**West Yorkshire Police
Kirklees District**

| To: Rebecca Drake | Ref: 2019/90725 Date: 4 th April 2019 |

Site Location: Busker Lane, Scissett, HD8 9JU

Application Type: Full – 9 Apartments

GROUND FLOOR PLAN

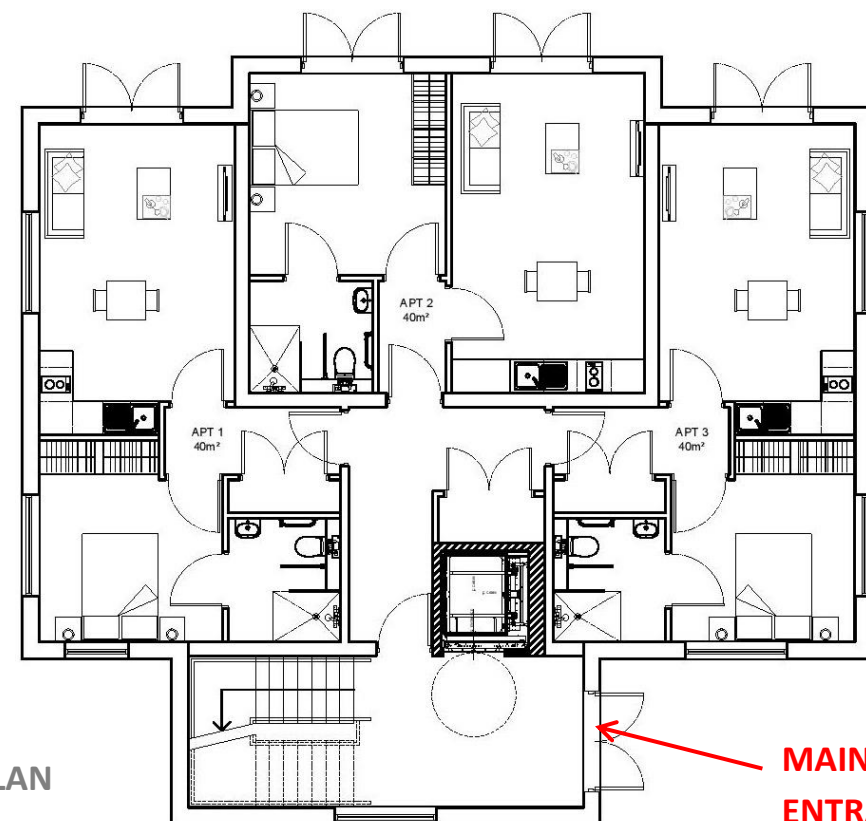
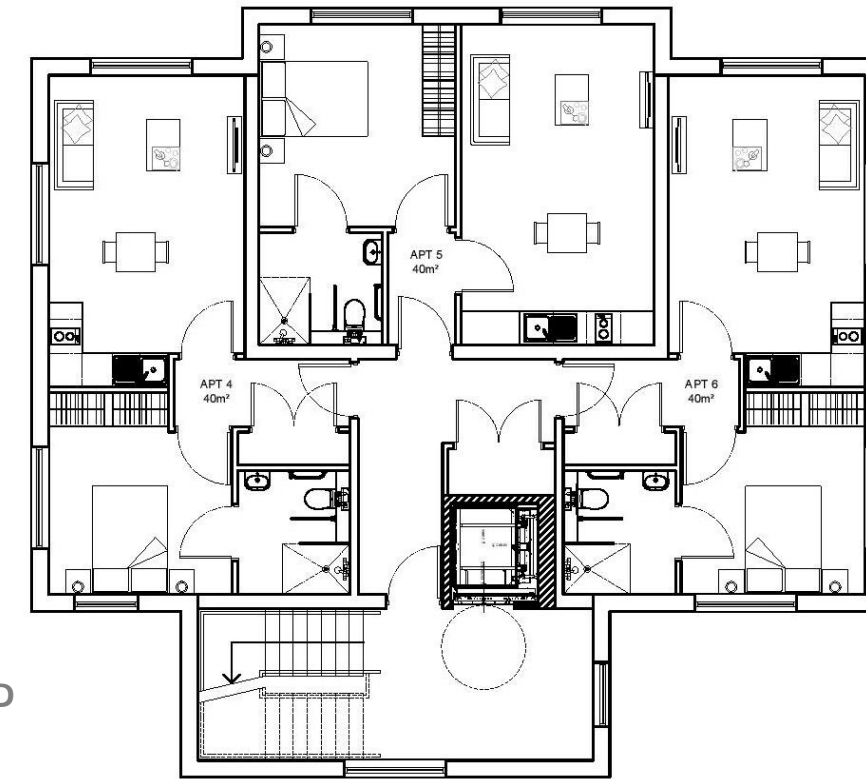
With reference to the Design and Access Statement Revision B dated Feb 2019, Section 04 Crime Prevention & Security. It is encouraged to install access control measures to the main entrance with audio and video feeds. It is essential for the building security, that staff training around rule setting is introduced around the closing and locking of external doors. Many of this type of property suffer with intrusion by offenders where doors are left propped open and not locked closed with the magnetic locking systems.

Proposed Ground Floor Plan  
Scale 1:100

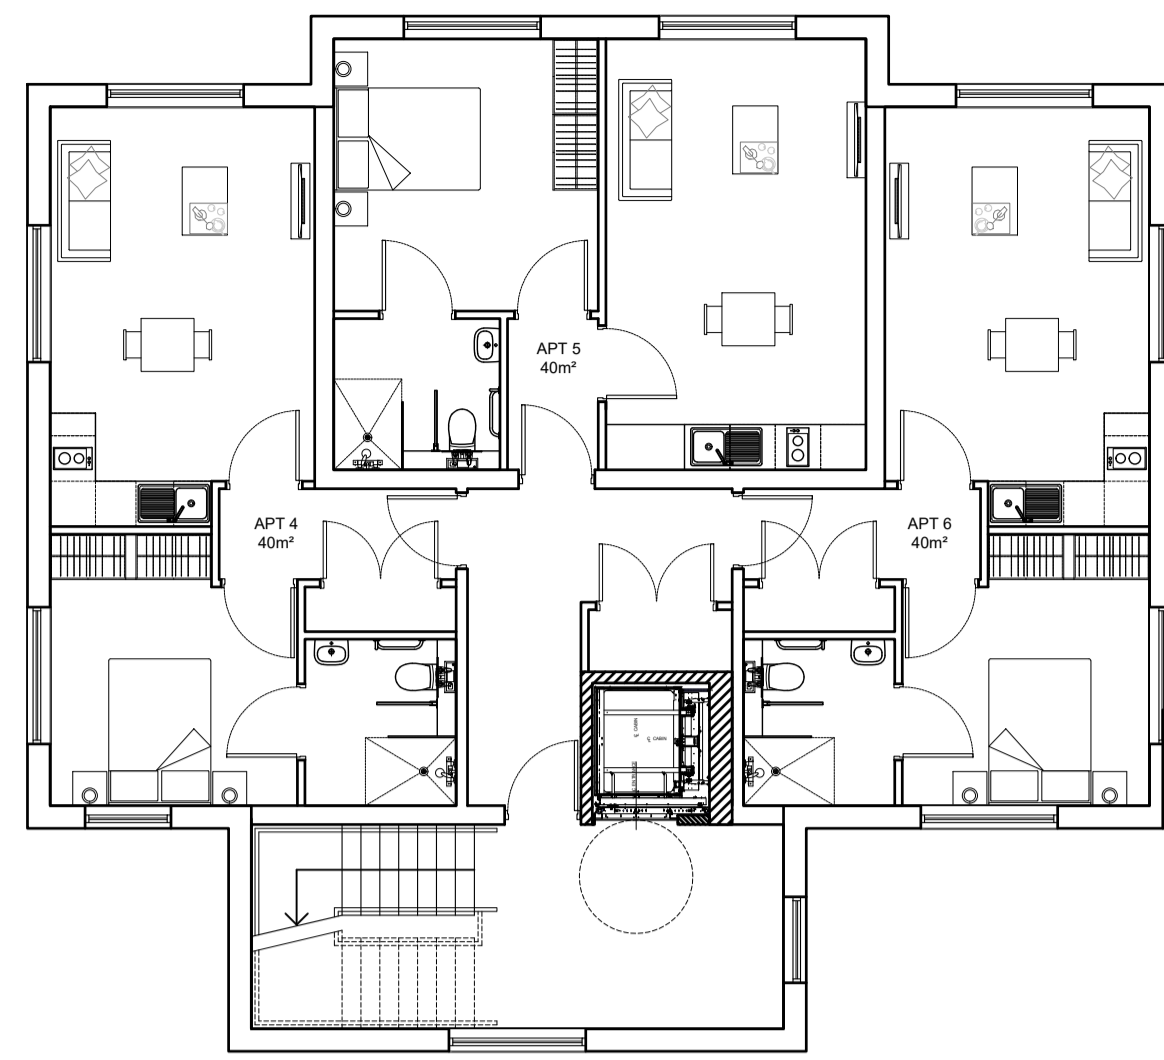
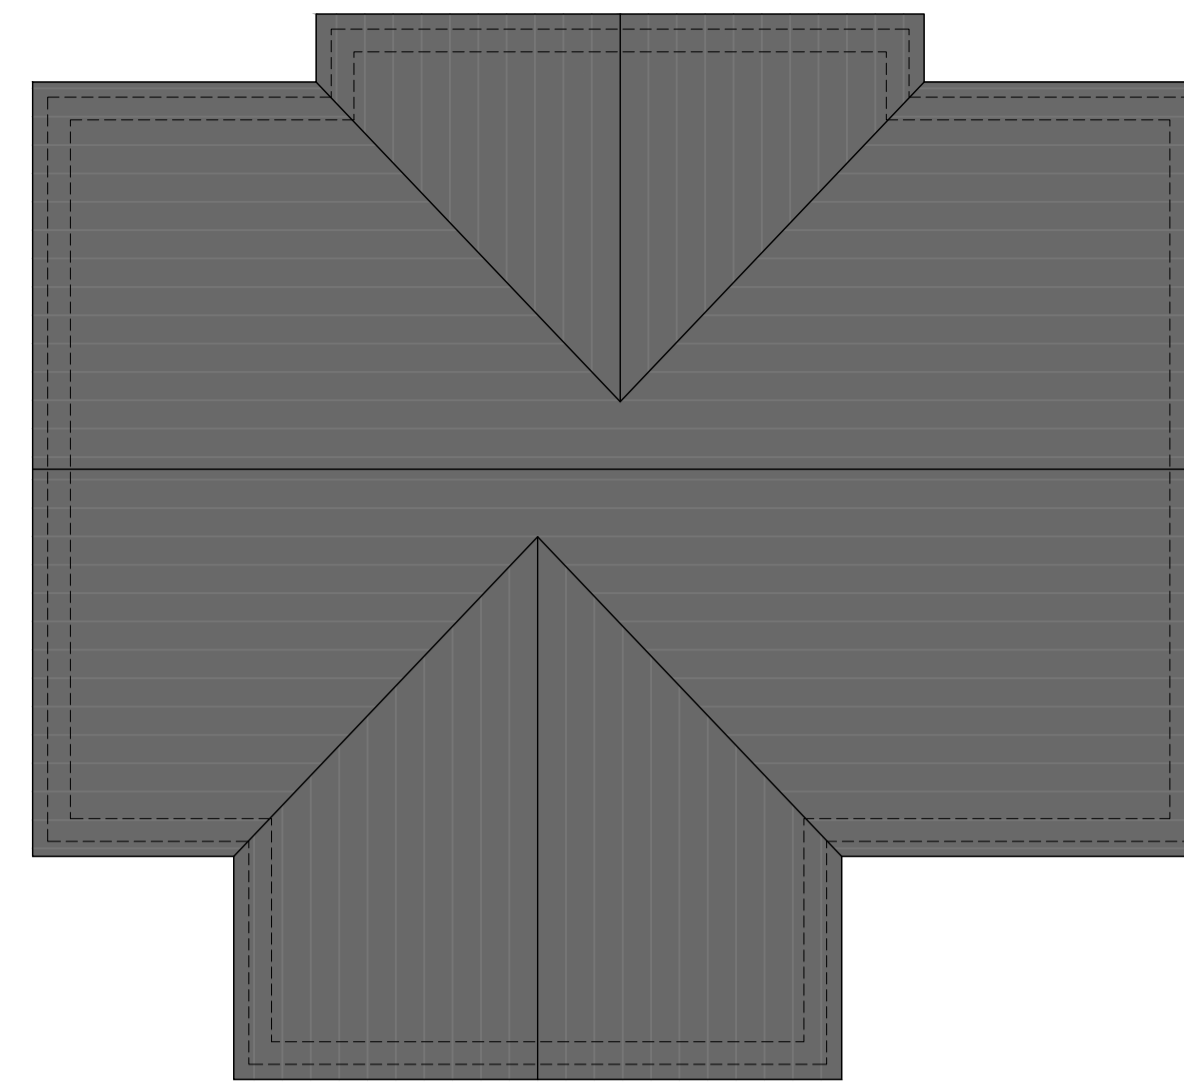
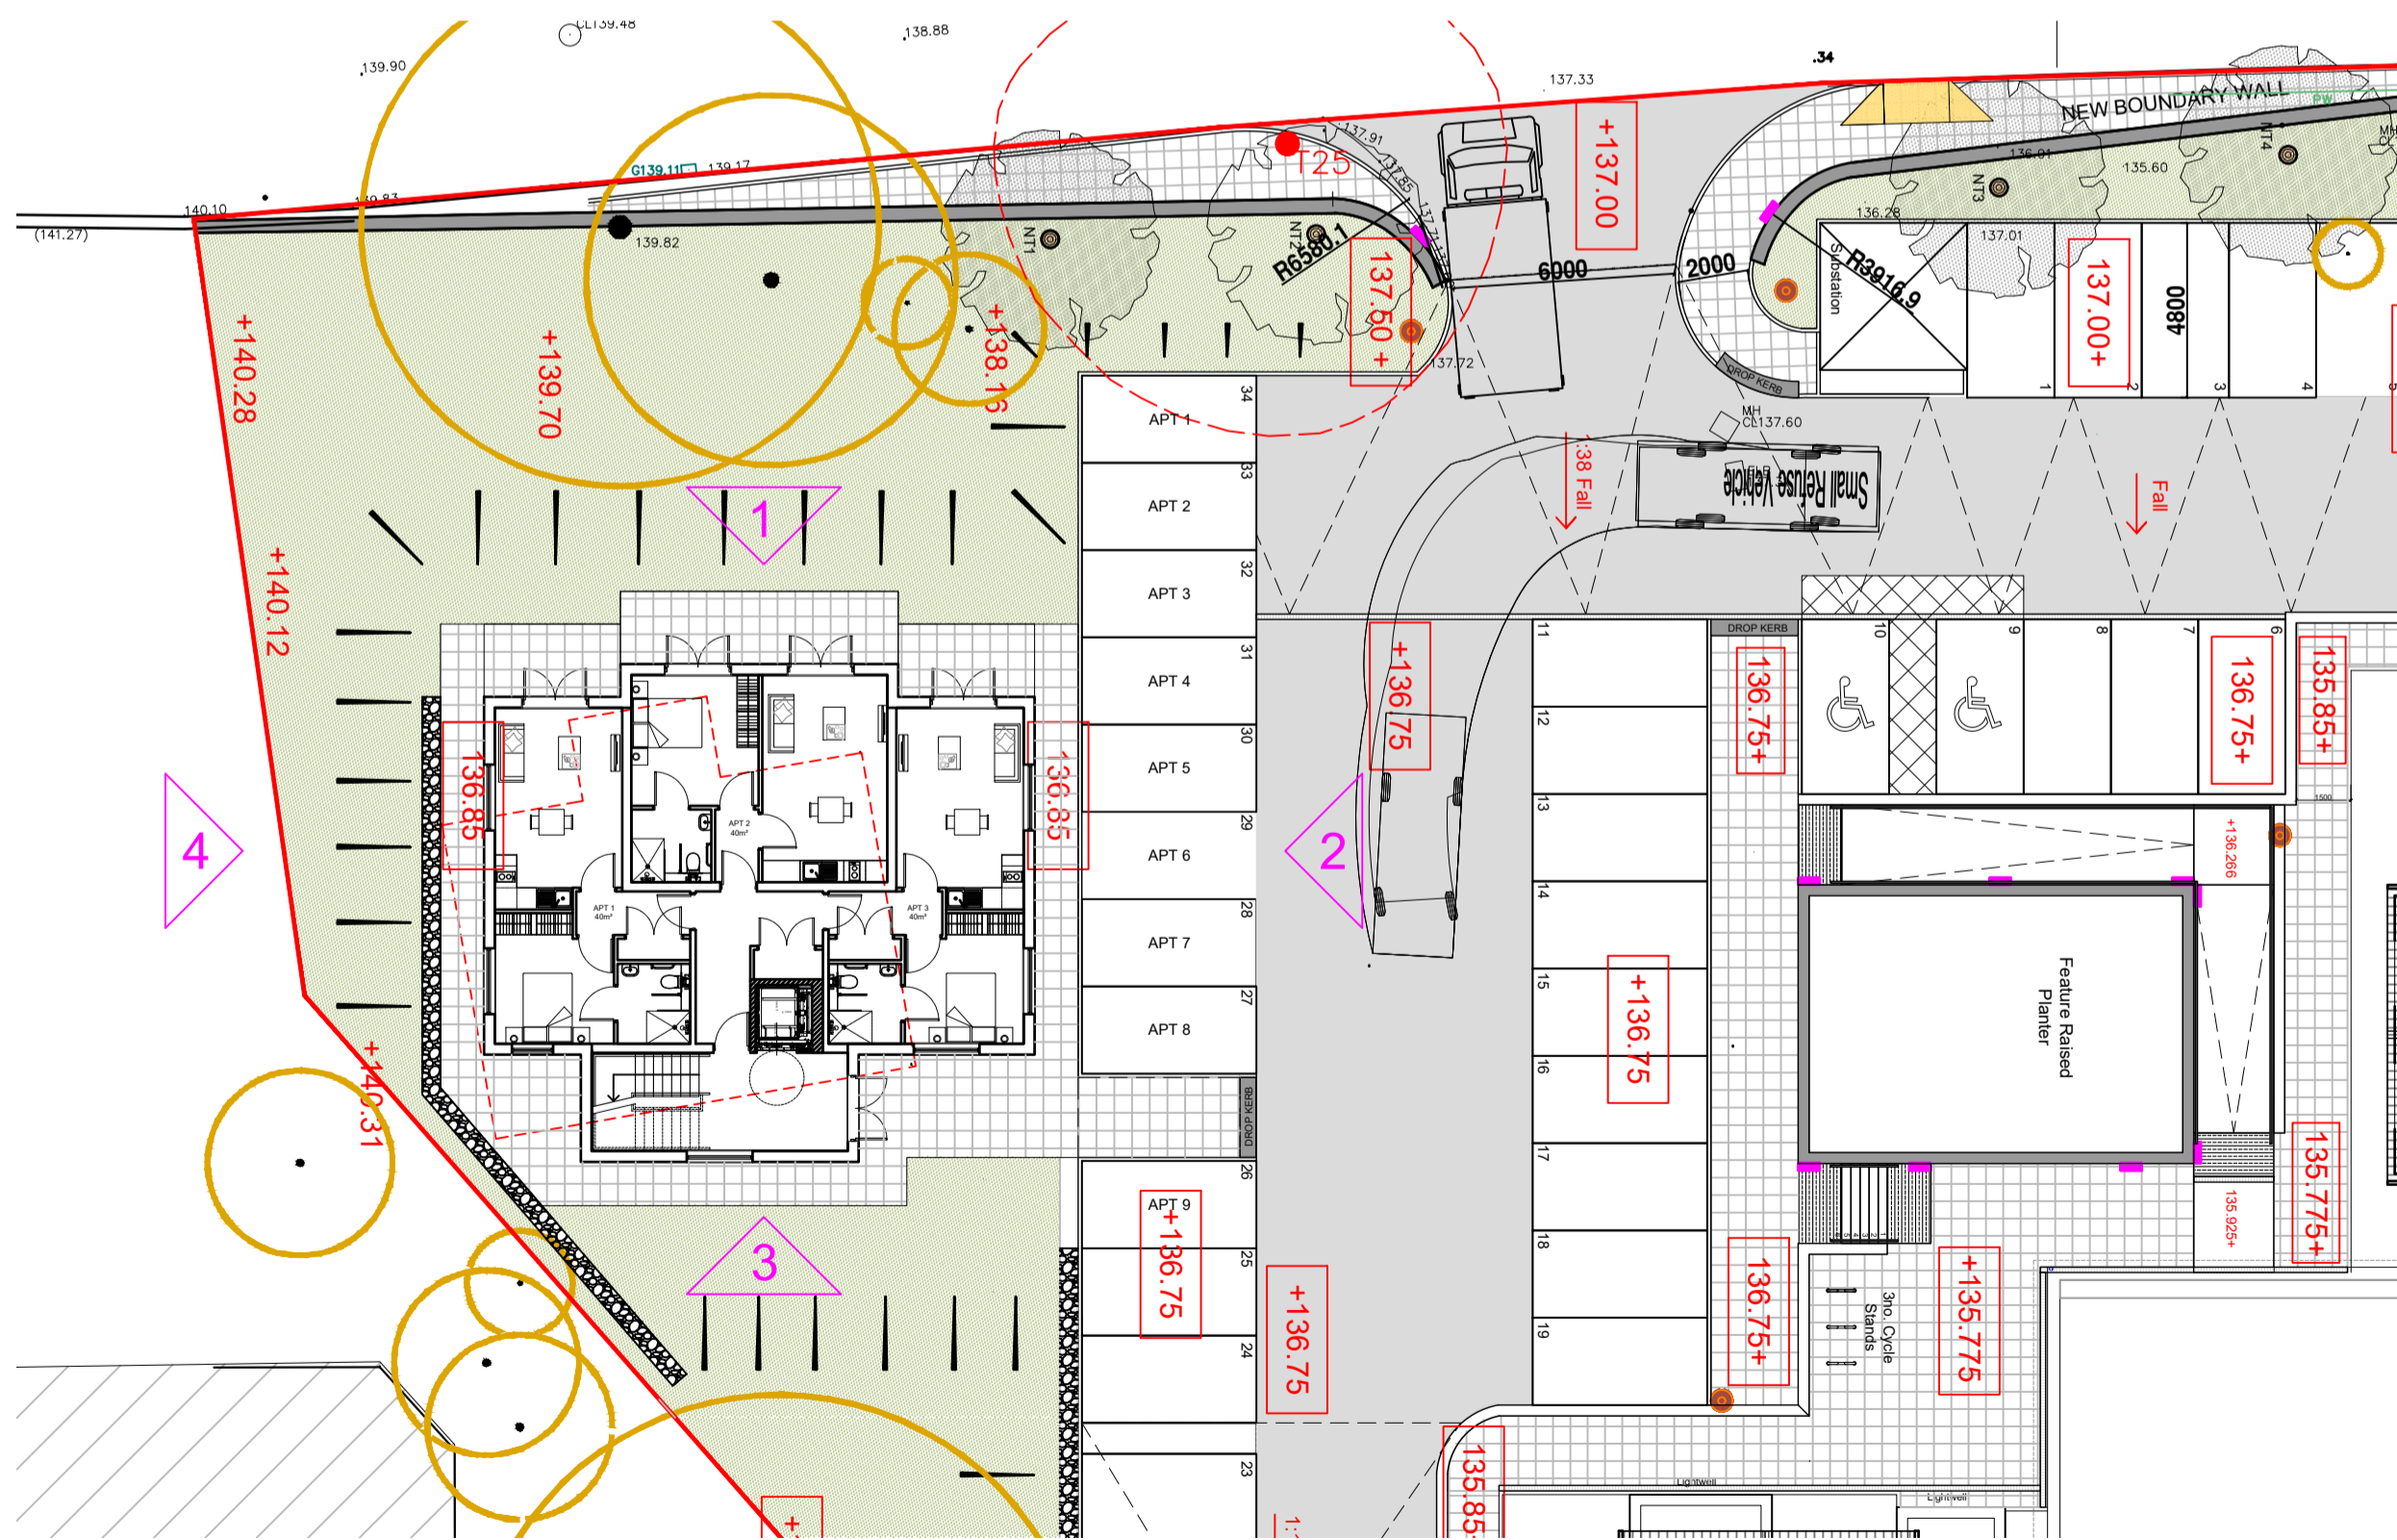
Consideration should be given to making the west and south aspects of the building at ground level secure with lockable gates and fencing to 1.8m high. The fencing could be attached to the retaining wall with the gates flush with the building line at the front and angled from the south west corner of the building. This would protect the rear and side ground floor windows from forced entry by offenders.
